Item No. **Report of the Head of Development Management and Building Control**

Address: OAKDALE DENTAL PRACTICE 103 PINNER ROAD NORTHWOOD

Development: Installation of external staircase from ground to first floor

LBH Ref Nos: 21303/APP/2025/3113

Job No. 2025/PRN Date 02/12/2025	Job 103 Pinner Road 103 Pinner Road Northwood HA6 1QN	Drawing PROPOSED SIDE ELEVATION	Drawing No.		Revision		0m 1m 2m 3m 4m 5m 6m 7m 8m 9m 10m	PAPER SIZE: A3	SCALE 1:100
			Drn	Chk					
			LK	BK

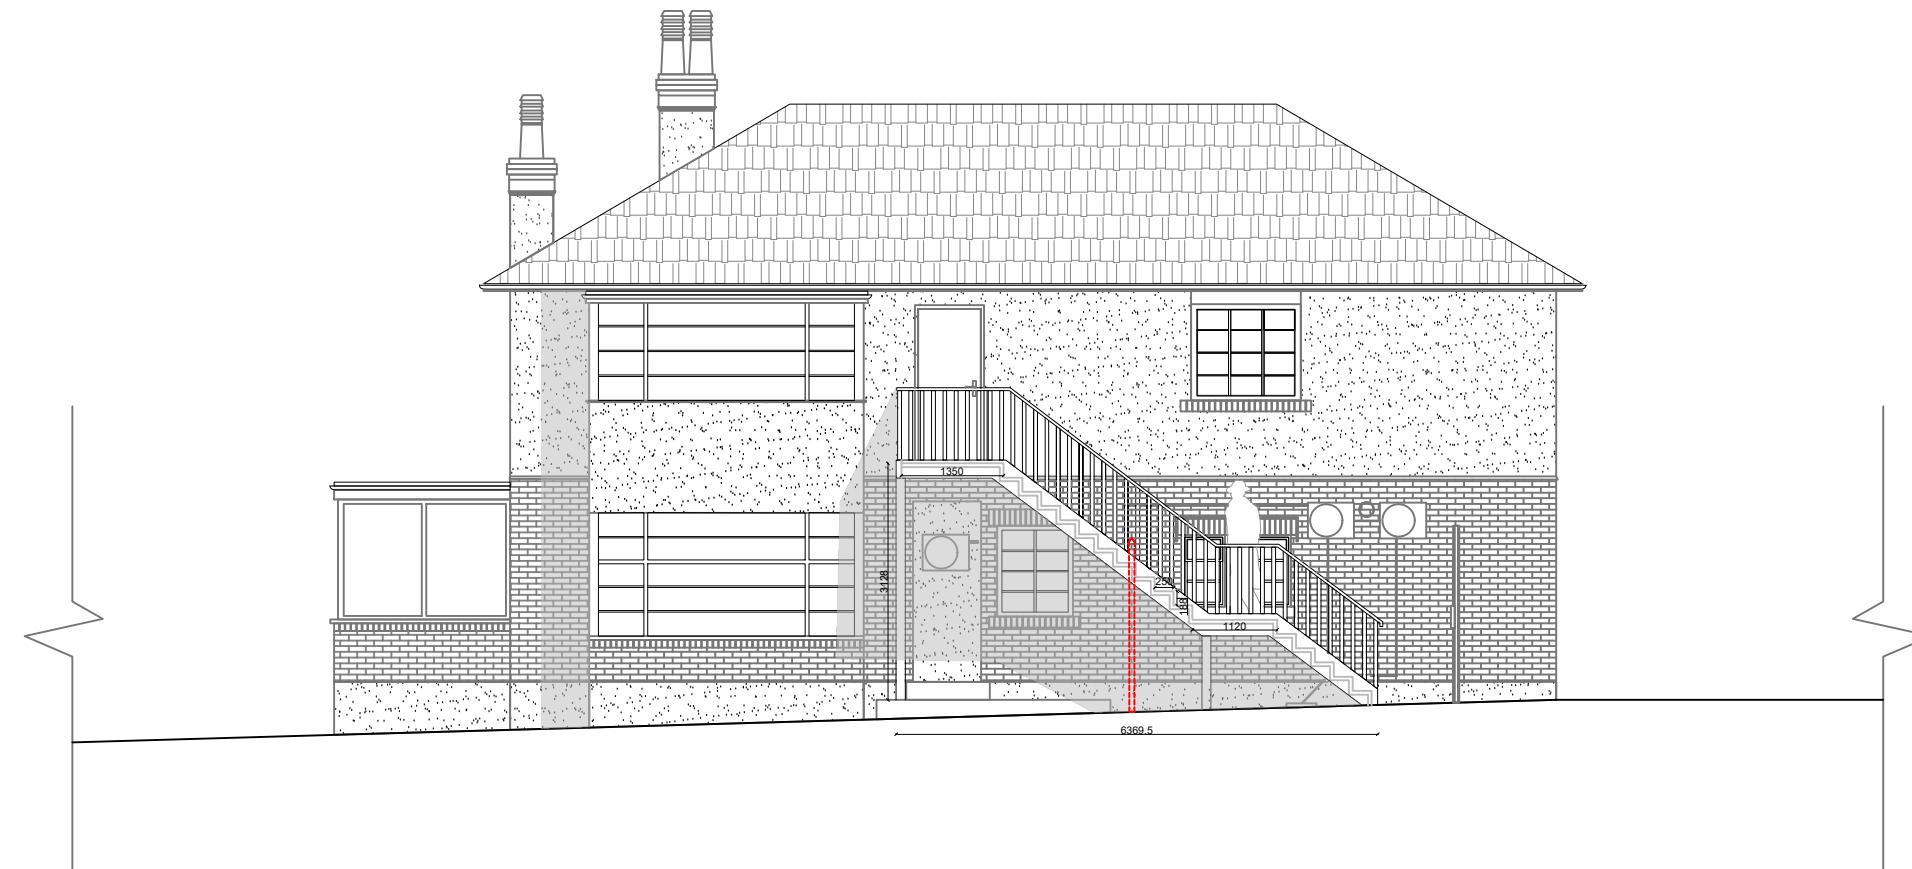
The proposed external staircase would be located on the eastern elevation of the building, facing towards the side elevation of Nos. 101 and 101A Pinner Road. The staircase would be positioned approximately 3 metres from the shared boundary, with the host building itself set around 3.9 metres from the boundary, providing a reasonable degree of physical separation.

Whilst some oblique views would be possible from the upper landing, these would be limited in duration and extent, given the staircase is purely for access and not a space where occupants would reasonably linger. The landing areas are modest in size (approximately 1.1m and 1.35m deep) and the outward-opening door further limits any opportunity for prolonged use. A condition would be imposed to ensure the staircase is used solely for access and does not function as a balcony or amenity space, thereby safeguarding neighbouring privacy.

In addition, the staircase replaces an existing projecting porch structure, such that the increase in built form and perceived enclosure to neighbouring properties would be limited. Given the modest scale, separation distances, and functional nature of the staircase, it is not considered that the proposal would result in harmful overlooking, loss of privacy, loss of light, or overbearing impact to adjoining occupiers.

The proposed external staircase would be located on the eastern side elevation in a discreet position with limited visibility from the public realm. The staircase would be modest in scale, lightweight in appearance and clearly subordinate to the host building. It would also replace an existing projecting porch structure, such that the perception of additional built form would be limited. As such, the works would not materially alter the building's form, proportions or architectural character.

The application form states that the staircase would be constructed in stainless steel; however, no details of finish, colour, coating or treatment have been provided. A condition is therefore recommended to secure a dark, recessive finish to ensure the staircase remains visually subordinate and sympathetic to the host building, in accordance with Policies DMHD 1 and DMHB 11.

The external staircase hereby approved shall be constructed in stainless steel and finished in a dark, recessive colour and thereafter retained as such.

The external staircase and associated landings hereby approved shall be used solely for the purpose of providing access to the first-floor accommodation and shall not be used as a balcony, terrace, sitting-out area or other amenity space at any time.
